**WELWYN HATFIELD BOROUGH COUNCIL
EXECUTIVE DIRECTOR - PLANNING, PUBLIC PROTECTION AND GOVERNANCE**

DELEGATED APPLICATION

Application No: 6/2018/0225/HOUSE
Location: 31 Selwyn Crescent Hatfield AL10 9NL
Proposal: Erection of first floor side extension and single storey rear extension
Officer: Mrs Kerrie Charles

Recommendation: Refused

TITLE:-
Plans and Elevations
as Proposed

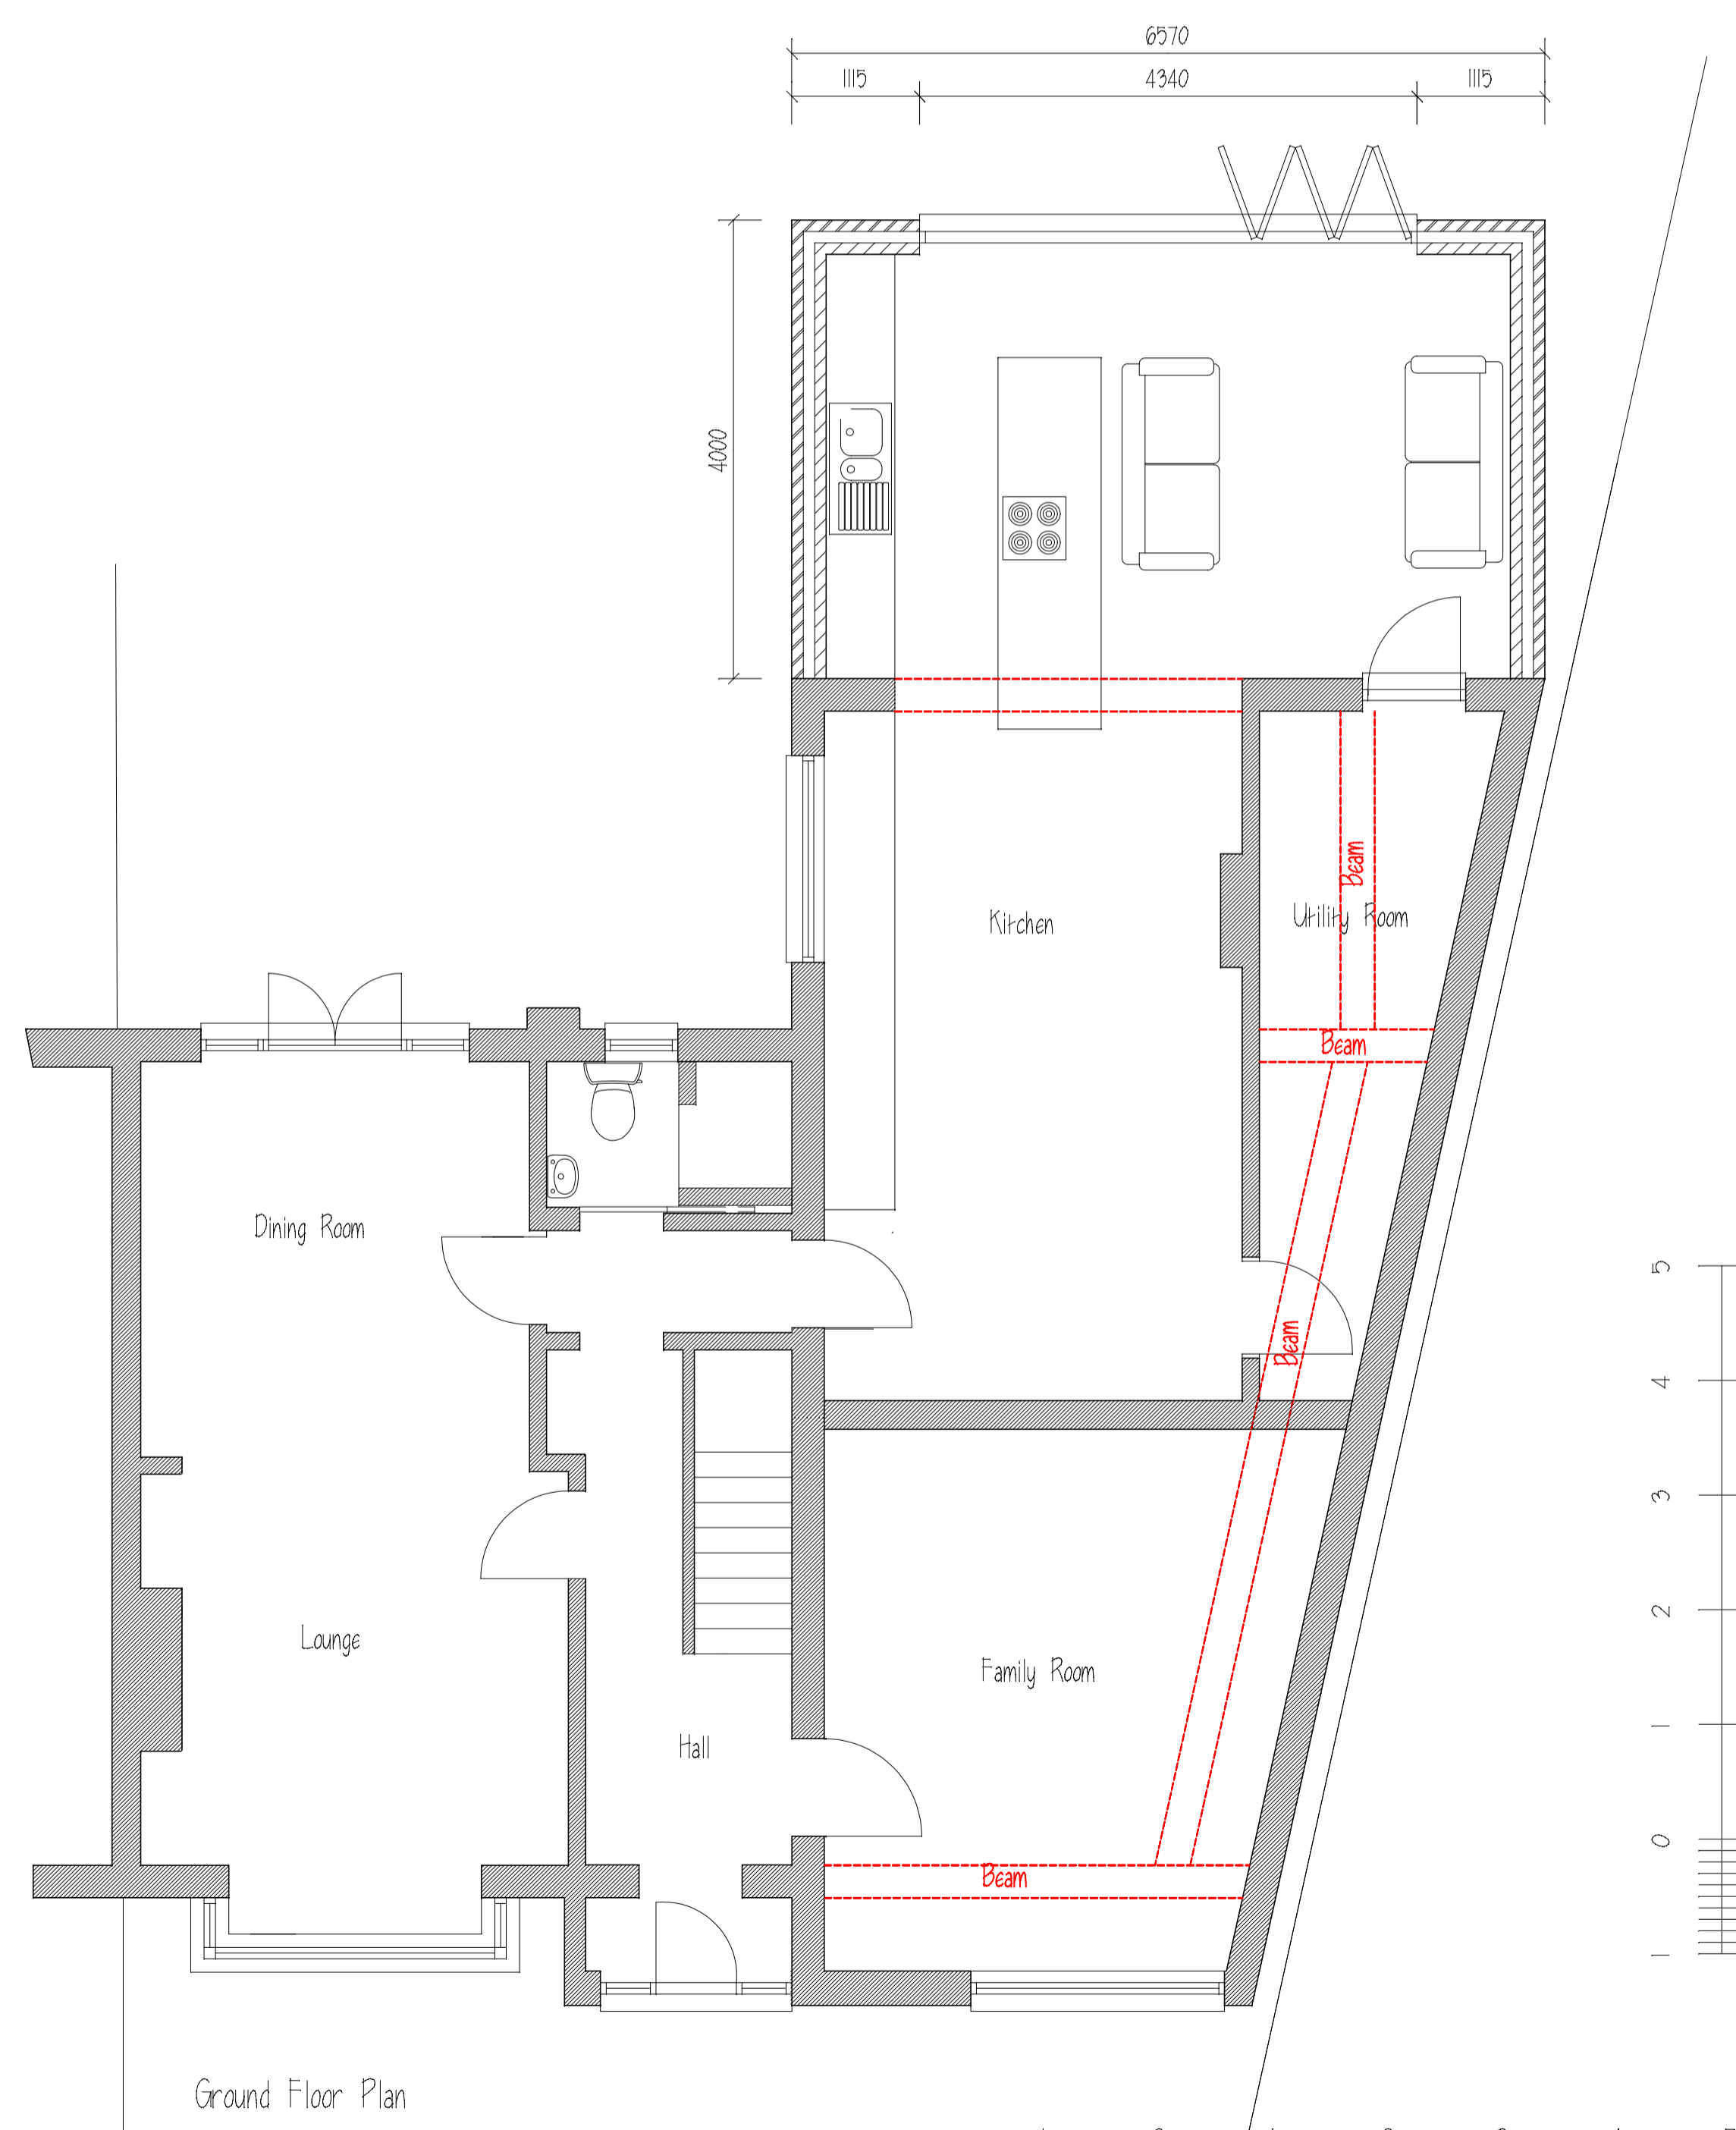
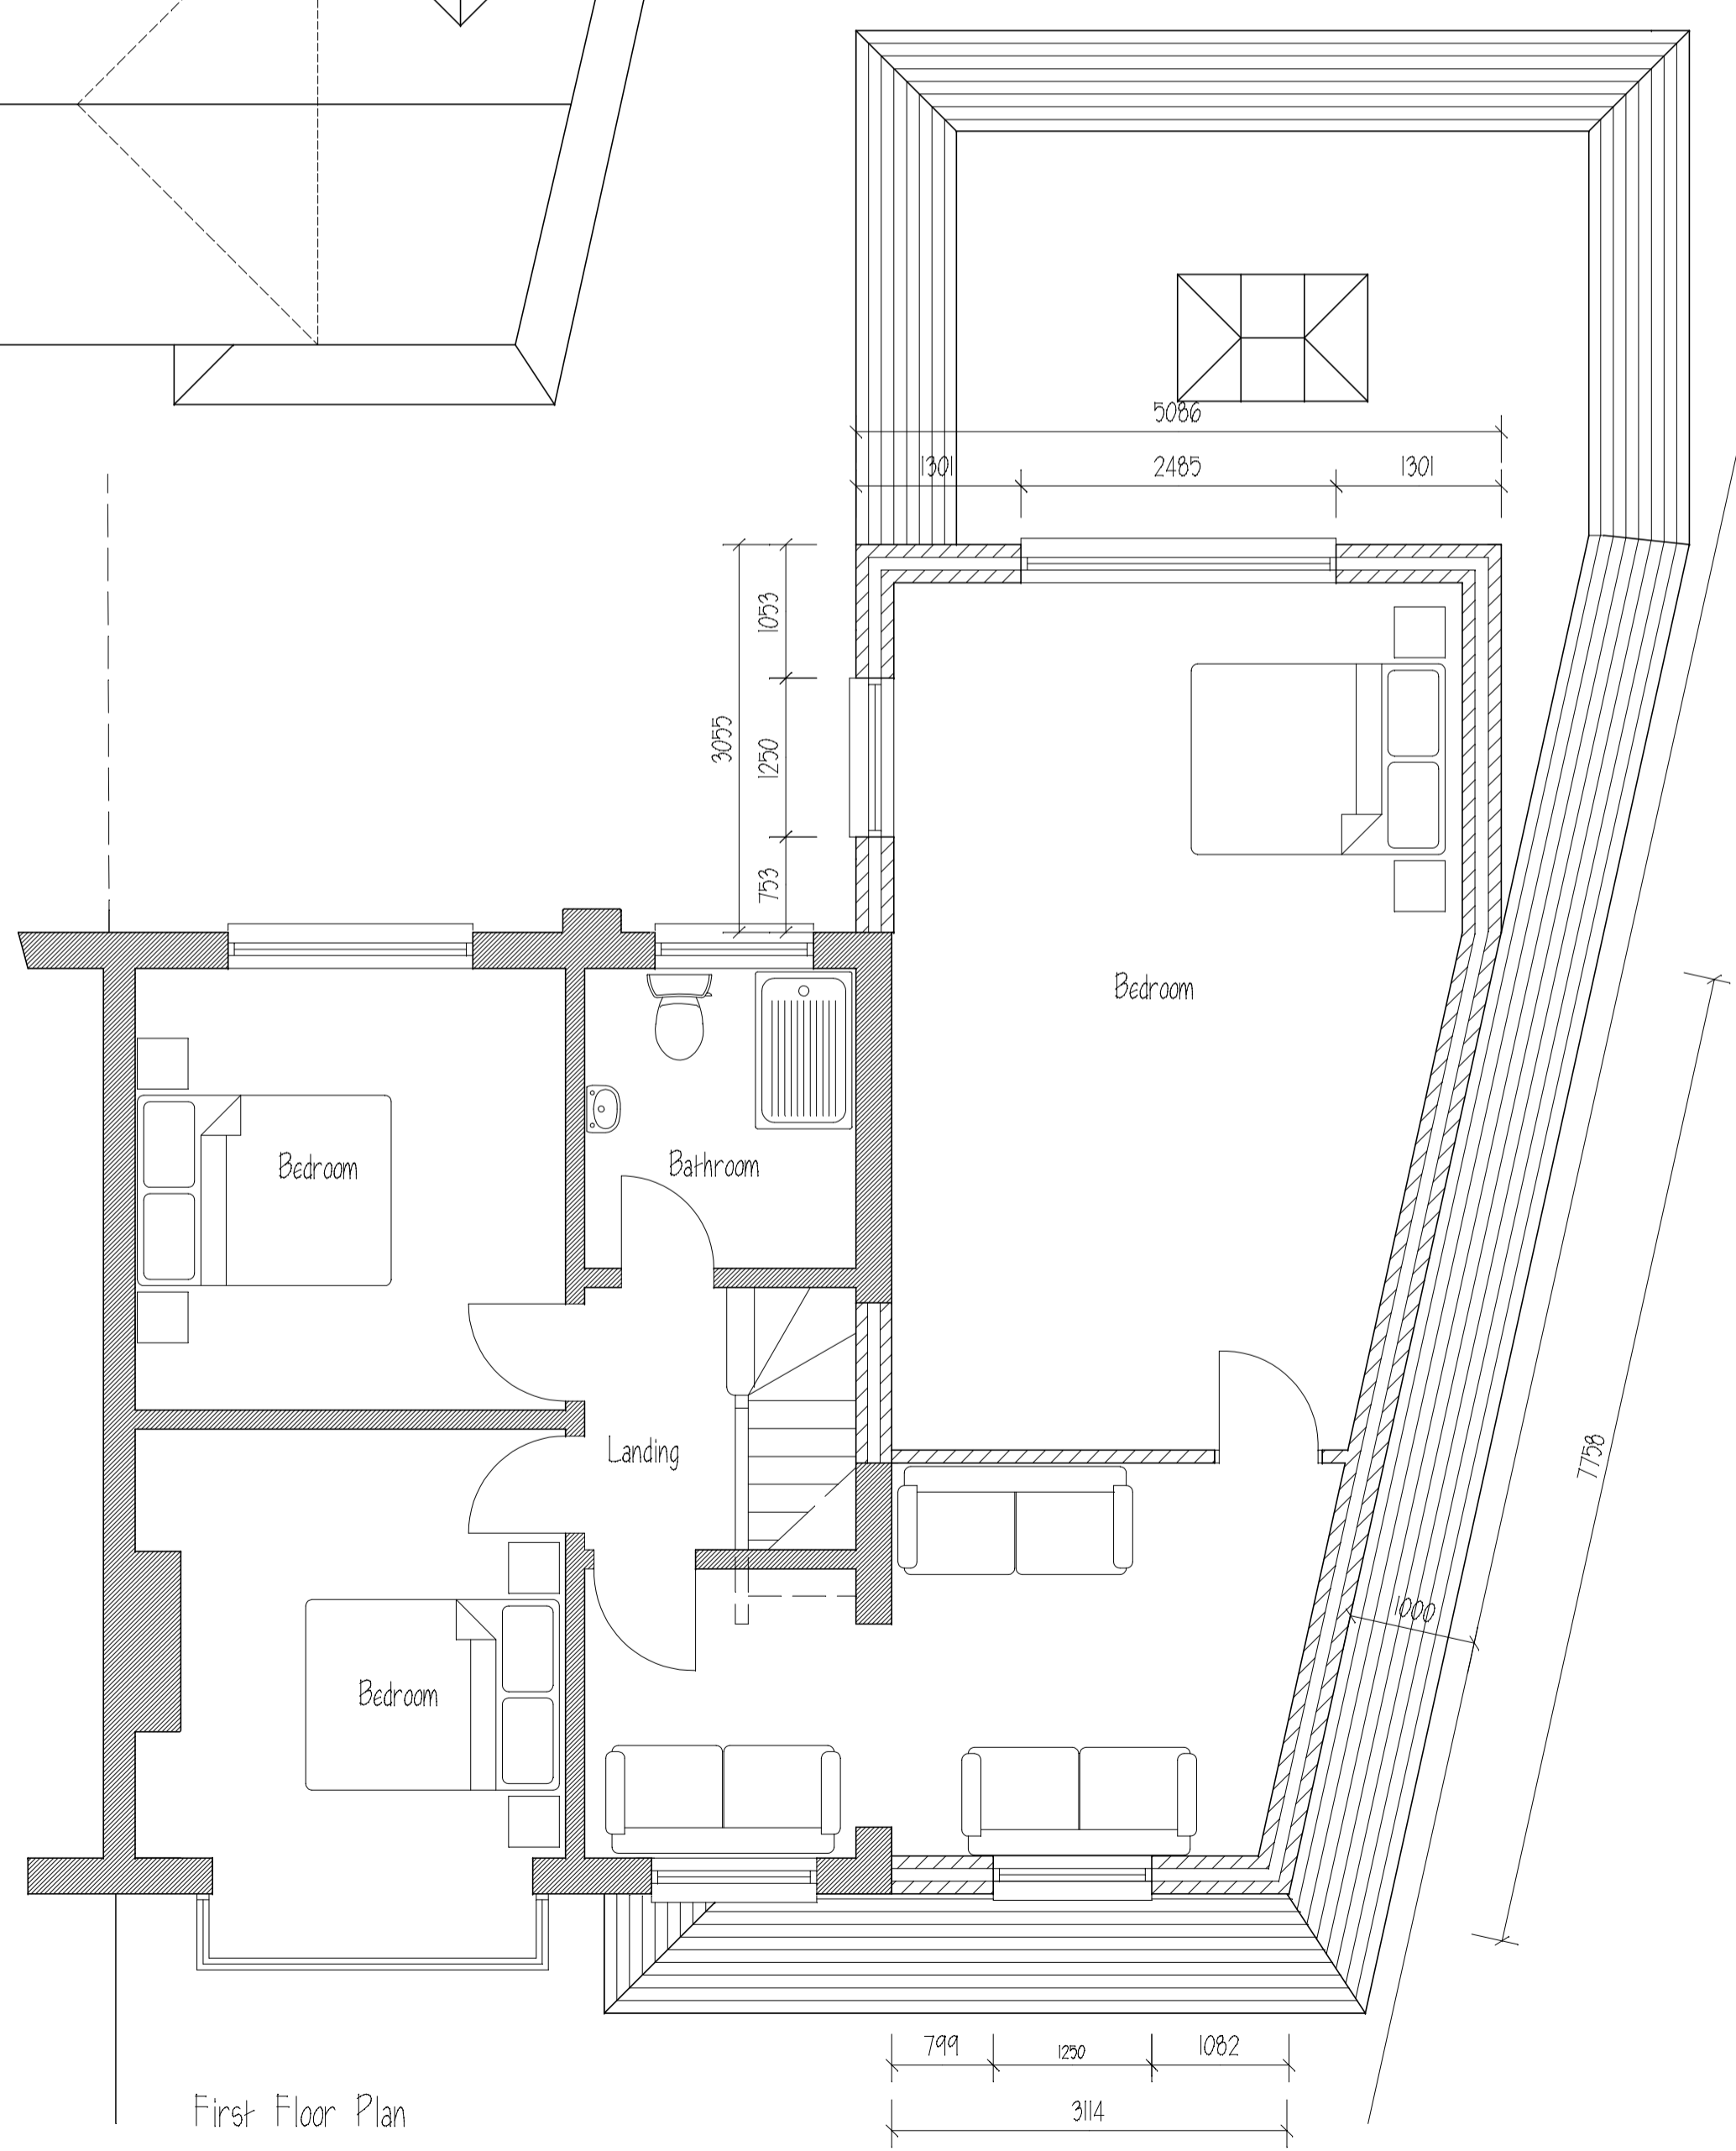
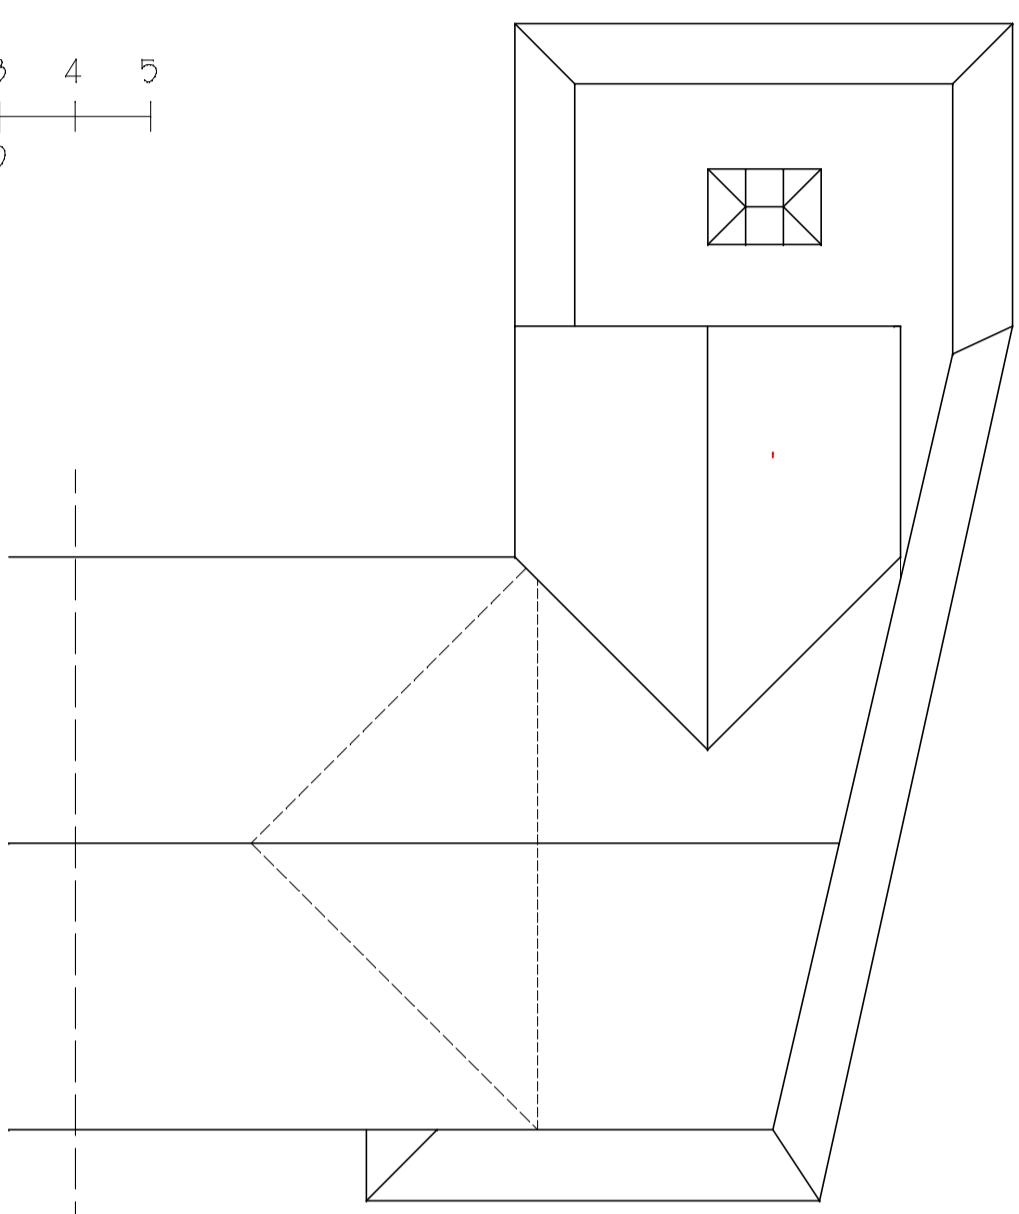
Impact on neighbours	The neighbour most likely to be affected by the proposal is No. 33 Selwyn Crescent. The proposed development would extend further back beyond the adjacent property. Although the development would be within closer proximity

<p>to the common boundary, the first floor element, would not be unduly dominant or result in loss of light to this adjacent property.</p> <p>In terms of privacy, new first floor side windows serving a bedroom and family room would be installed. This window would present views toward the flank window of this adjacent property. As such, in the event of a grant of planning permission, it would be considered necessary and reasonable for this window to be glazed in obscure glass and have a restricted level of opening in order to maintain the levels of privacy enjoyed by the occupier(s) of No. 33.</p> <p>This property is attached to the host dwelling. It is not considered that the proposed development being single storey would result in a detrimental impact on the residential amenity of this neighbouring occupier in terms of loss of light, appearing unduly dominant or result in an impact on privacy.</p> <p>Overall, it is considered that the living conditions of the adjoining occupiers are maintained to an acceptable level in accordance Policy D1 Welwyn Hatfield District Plan 2005 and Supplementary Design Guidance 2005.</p>

1. The proposed development, by virtue of its scale and proximity to the flank boundary, would result in overdevelopment across the plot width and depth of site, would fail to reflect the established spacing of dwellings adjacent to and in the immediate locality of the site and represents an incongruous addition relative to the character and design of dwellings in the street scene. Accordingly, this proposal represents a poor standard of design contrary to Policy D1, D2 and GBSP2 of the Welwyn Hatfield District Plan 2005, Supplementary Design Guidance (Statement of Council Policy 2005) and relevant parts of the National Planning Policy Framework 2012.
